**Our ref:** WA/2023/130772/04-L01

**Your ref:** 23/02098/OUT

### **Begbroke Science Park and Surrounding Land**

### **Environment Agency position**

Figure 3.5: Peak water level differences between the proposed and baseline conditions for the 1% AEP event with 41% climate change allowance.

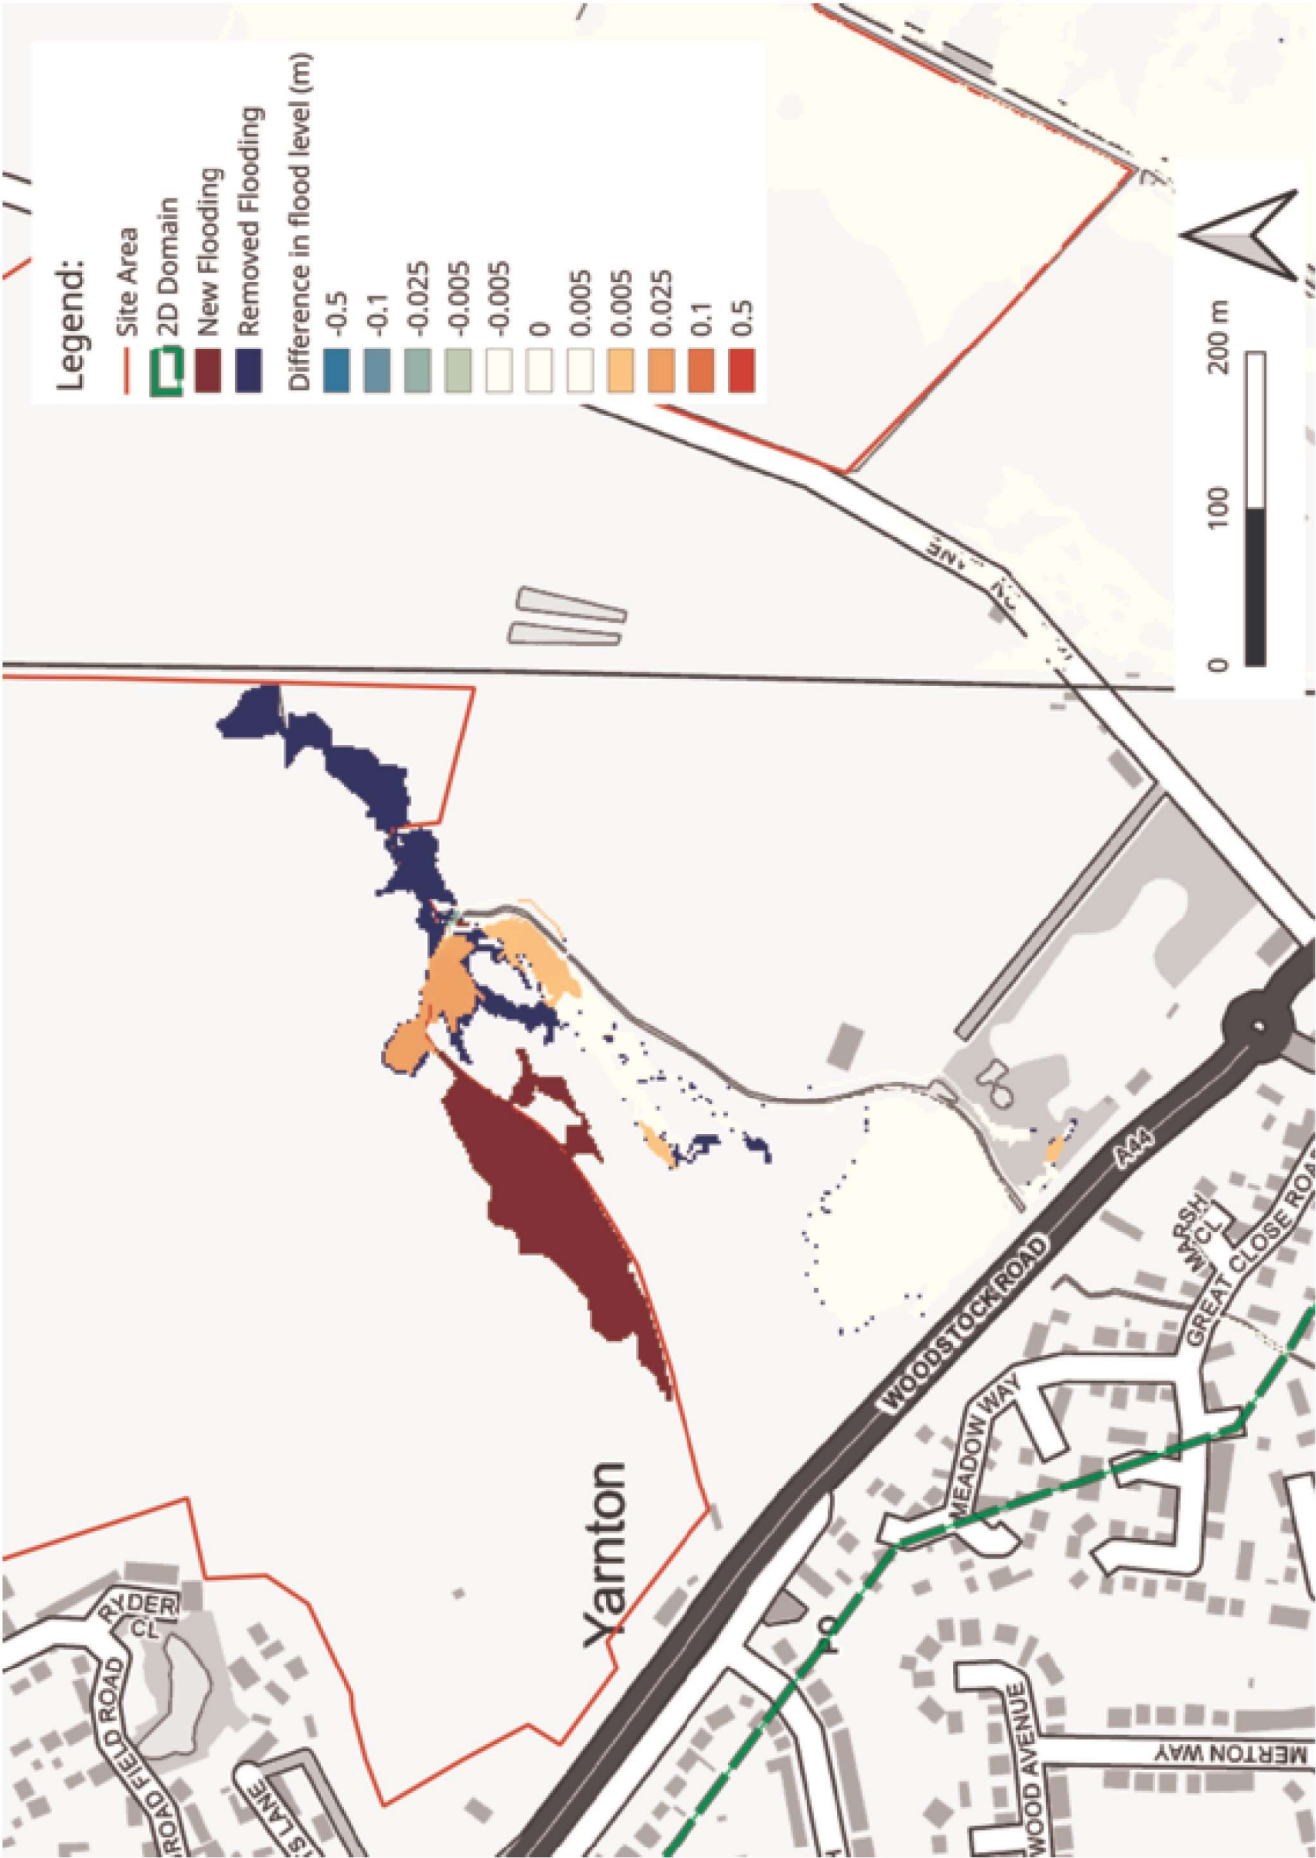
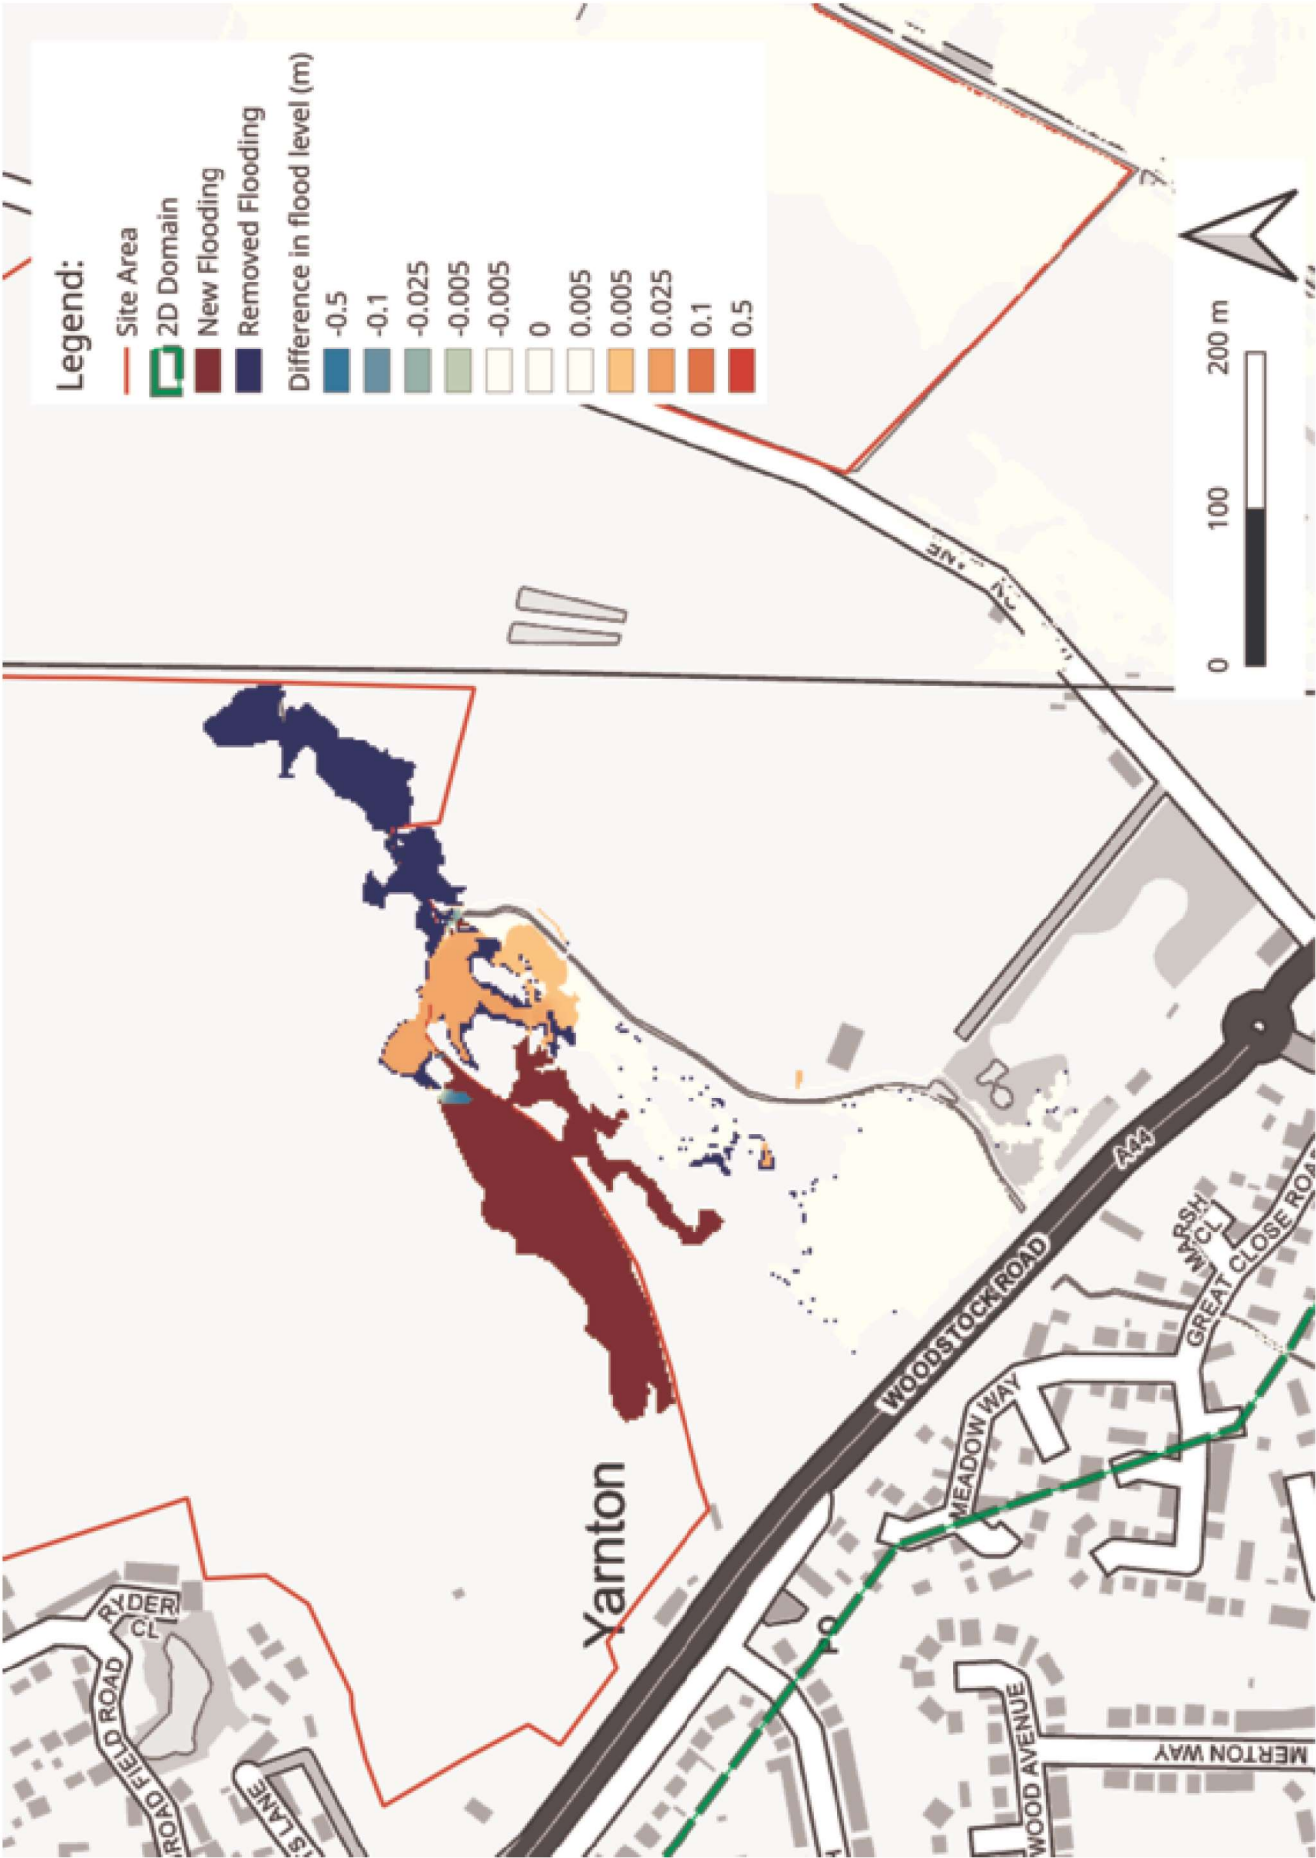
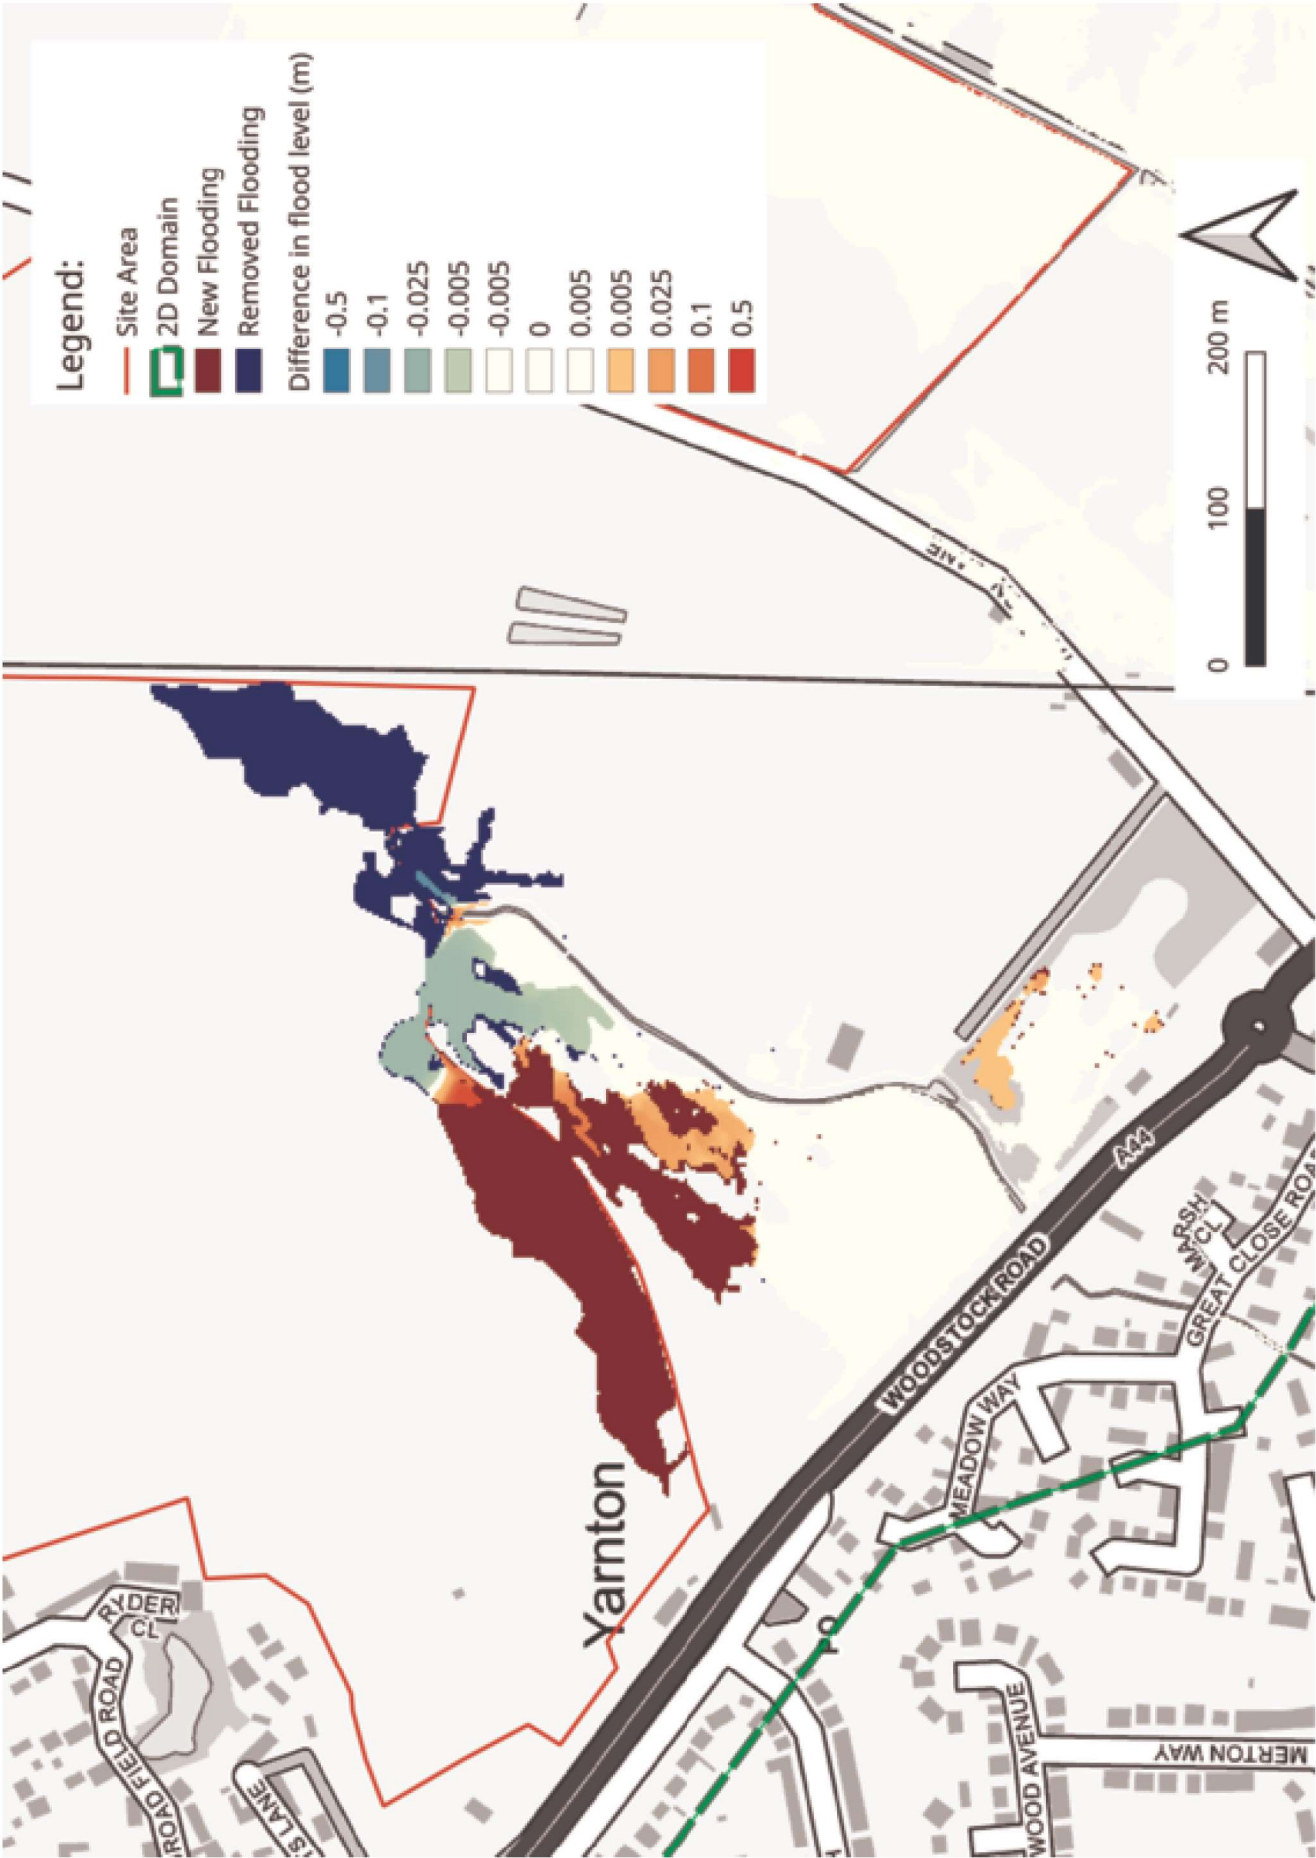
The previous submission did not model the impacts of a FSA, and only showed that without one there would be an increase in flood risk on and off site which is not acceptable. The submitted modelling now proposed mitigation in the form of a Flood Storage Area (FSA). Three proposed designs for the FSA have been modelled and assessed in this submission. We are satisfied with the quality of the modelling undertaken and that in a single rainfall event that option D8 should prevent increases in flood risk offsite.

However, we have concerns with the proposed design of the FSA in the modelling and are not satisfied the issue can be conditioned at this stage. In the 1% annual exceedance probability (AEP) plus 41% climate change scenario, the model shows the water level in the FSA after 40 hours is kept at 60.5mAOD which is roughly a depth of 65cm (levels in the FSA peak at about 1m as per the design). The north bank of the ditch which runs alongside the flood storage area acts as a weir with a crest level of 60.5mAOD. This is represented in the model but there is no clear way beyond this to enable the FSA to drain.

The technical note suggests that the water will discharge onward to the ditch network outside of the site boundary but this does not appear to be represented in the current modelling. It is not clear how the FSA would drain further, this may require some kind of control structure. At this stage, it is not known whether it is feasible for the FSA to drain fully without having to redesign the scheme. Details of how the FSA could fully drain in theory should be provided, including identifying if a control structure would be required and if so what type of control structure this would need to be.

Figure 1—3 – Illustrative Masterplan Layout

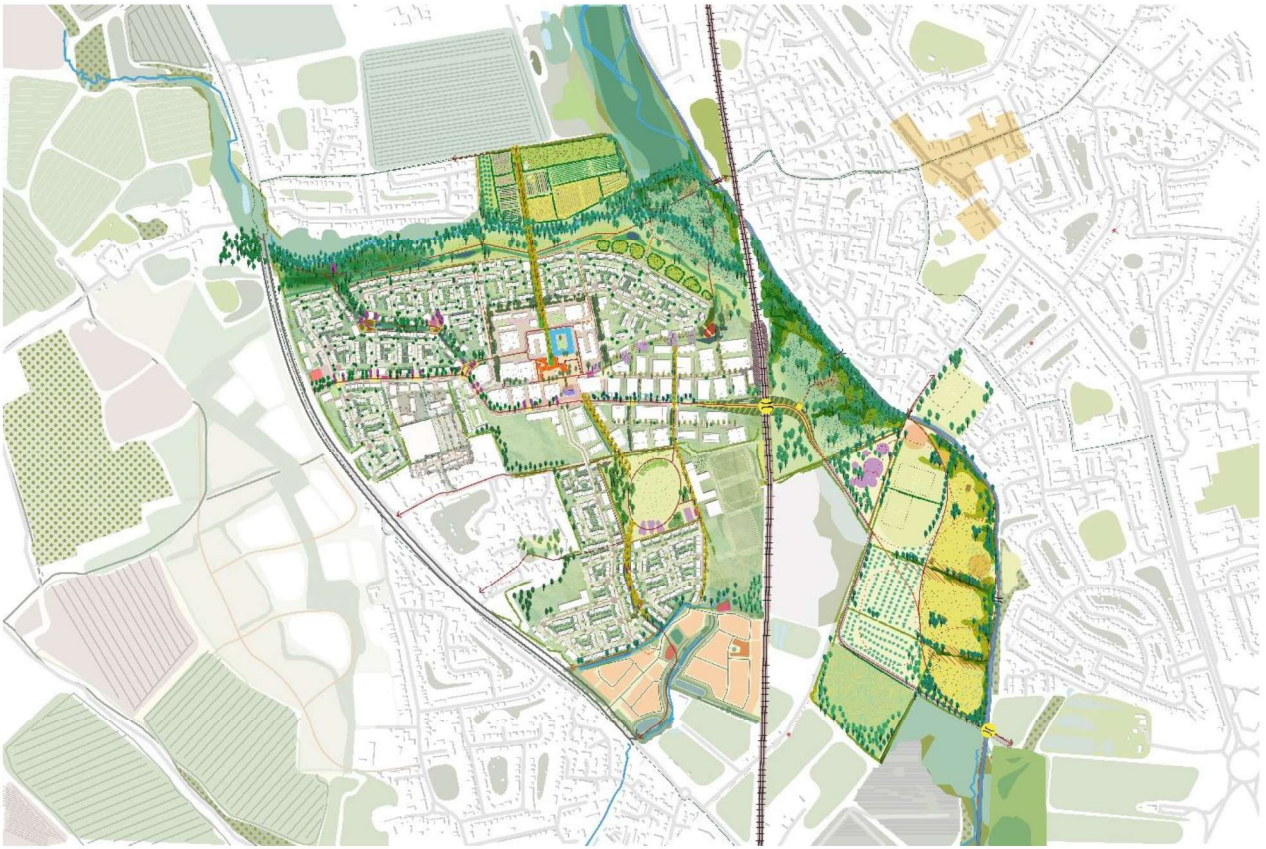
Please also be aware that the proposed FSA has had to be enlarged since the previous consultation to ensure it is large enough to prevent an increase in flood risk on and offsite. From comparing plans, the FSA may now be required where dwellings are proposed. This has not been discussed in the applicant's additional information and no new site plan has been provided.

Zones 2 and 3. This in turn is linked to the proposed FSA. Currently the modelling shows that a larger FSA than previously proposed would be required in order to prevent increases in flood risk to new dwellings and offsite. This larger FSA appears to be where dwellings are proposed. Whilst we don't believe the applicant proposes to put dwellings within their FSA, Proposed Plans should be provided to demonstrate this is not the case and that a feasible design option exists.
